SHEET NO.	TITLE
C0.0	COVER SHEET
C1.0	SITE PLAN
C1.1	SITE DETAILS
C1.2	SITE DETAILS
—	PHOTOMETRIC PLAN (BY EATON)
C5.1	PHOTOMETRIC DETAILS
L1.0	SITE LANDSCAPE PLAN
L1.1 — L1.5	LANDSCAPE PLAN
L1.6	LANDSCAPE DETAILS & NOTES
A1.1	ARCHITECTURAL ELEVATIONS
A1.2	CANOPY ELEVATIONS

KING SOOPERS #147  
FALCON MARKETPLACE  
LOTS 2 & 3, BLOCK 1

COVER SHEET

COVER SHEET

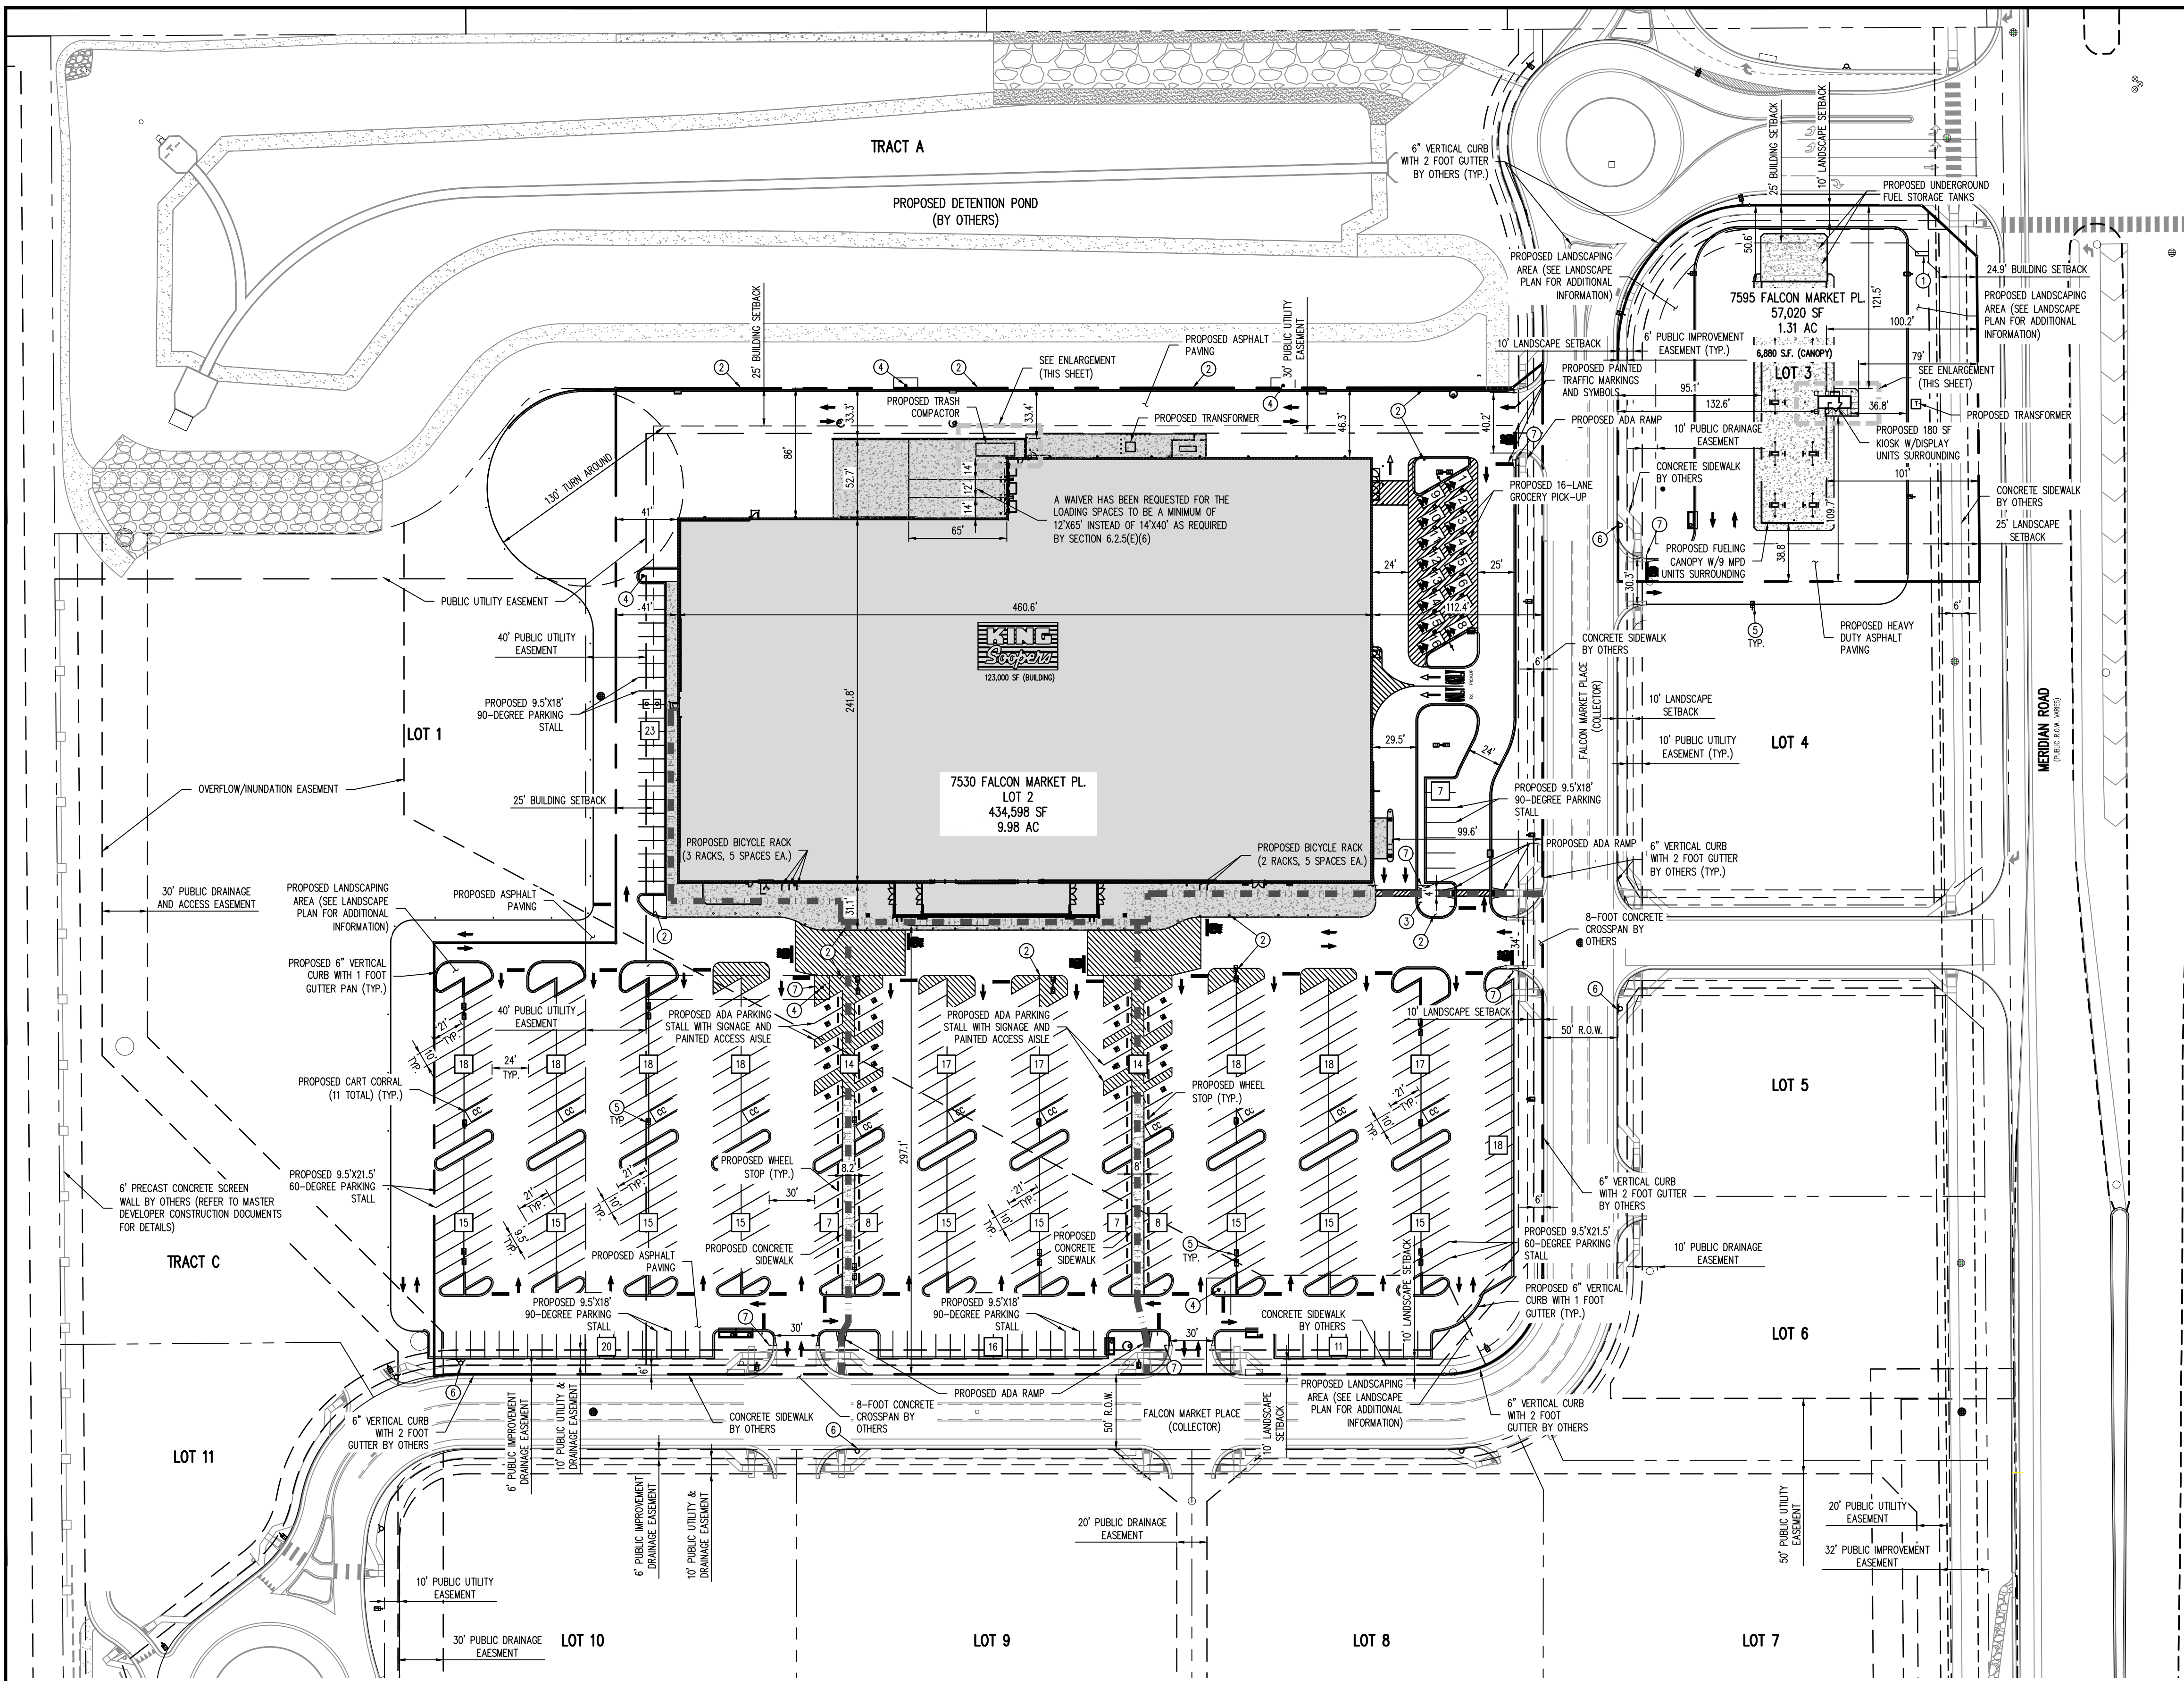
correct legal- Should be Lots 2 and 3 of the Falcon Market Place Subdivision. The acreage for lots 2 and 3 is not 37 + acres.
